18 October 2024

TfNSW reference: WST24/00335/001 | SF2024/171277
Your reference: SSD-48160216| PAE-75538717

SSD-48160216 - Environmental Impact Statement – Maison Dieu Solar Farm – Request for additional information

LEFT TURN
New England Hwy
& Magpie St

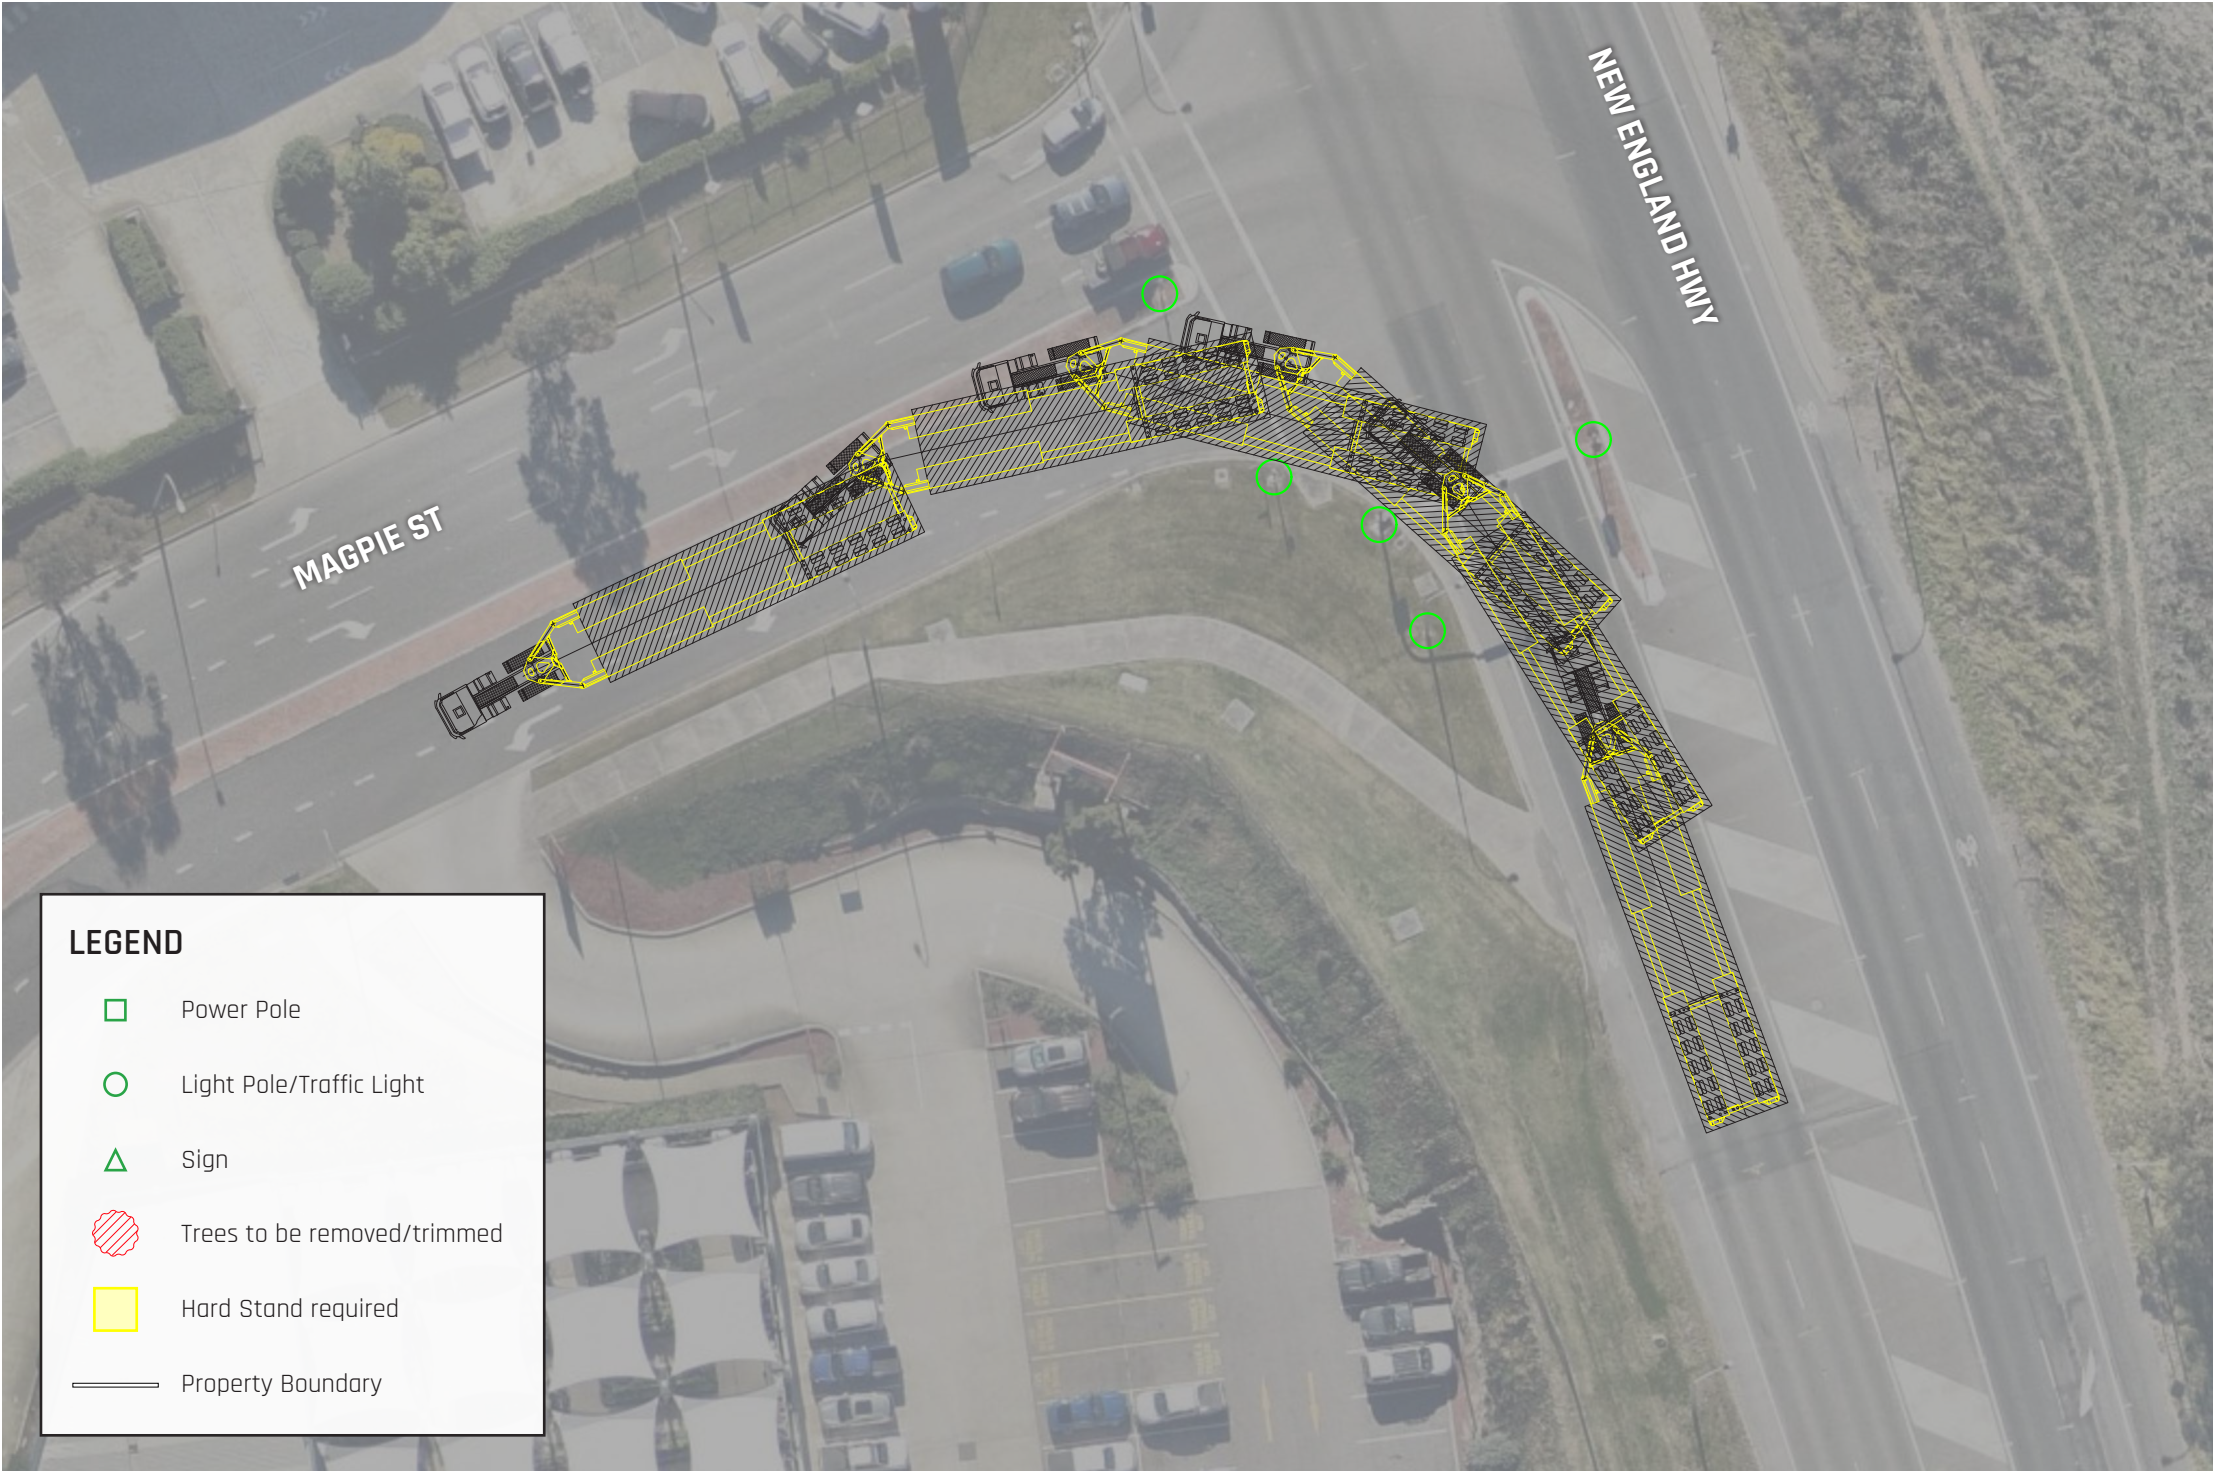
Clarification on how the prohibition and project traffic impacts for each intersection Magpie Street / New England Highway and Maison Dieu Road/New England Highway. The TIA currently identifies that the project traffic will turn left at the Maison Dieu Road/New England Highway and turn right from Magpie Street onto the New England Highway. High level traffic mitigation measures to enforce the proposed turning movements from and onto the New England Highway are to be identified within the revised TIA.
